Subject: RE: Planning Consultation on: AL/73/14/PL

APPLICATION NO: AL/73/14/PL

Site Address: Land adjoining Sunnyside Westergate Street Westergate PO20 3QR

Description of Works: Erection of 2 No three bedroom semi-detached dwellings (Plots 1a & 1b) together with new boundary treatment & landscaping & extension of access road to serve site (Part alternative to AL/114/12). This application affects a public right of way.

FIG 2 -
PROPOSED LAYOUT
& STRATEGY SCHEDULE

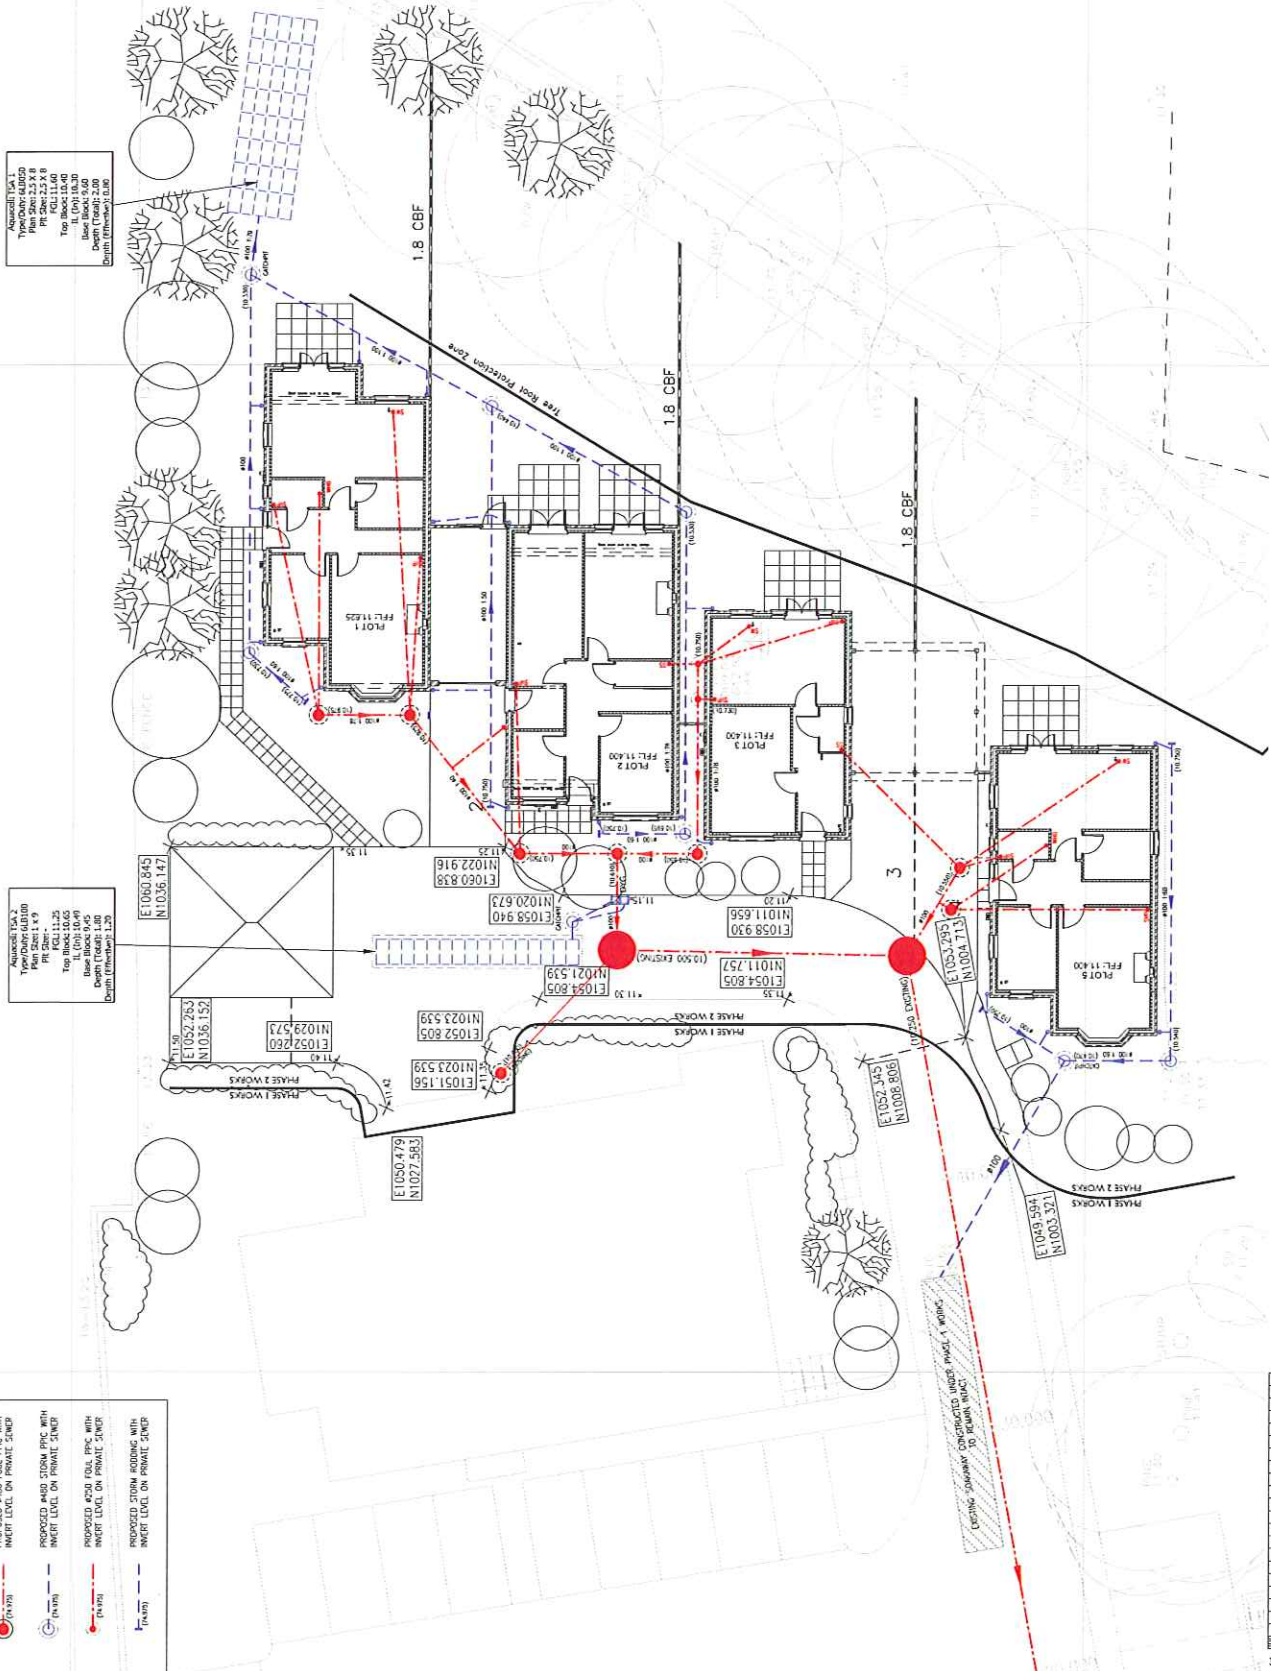
Soakaways to be designed for 1 in 100 year storm event plus 30% and designed in accordance with the groundwater and percolation results already obtained.

Please amend ENGD2A to suit.
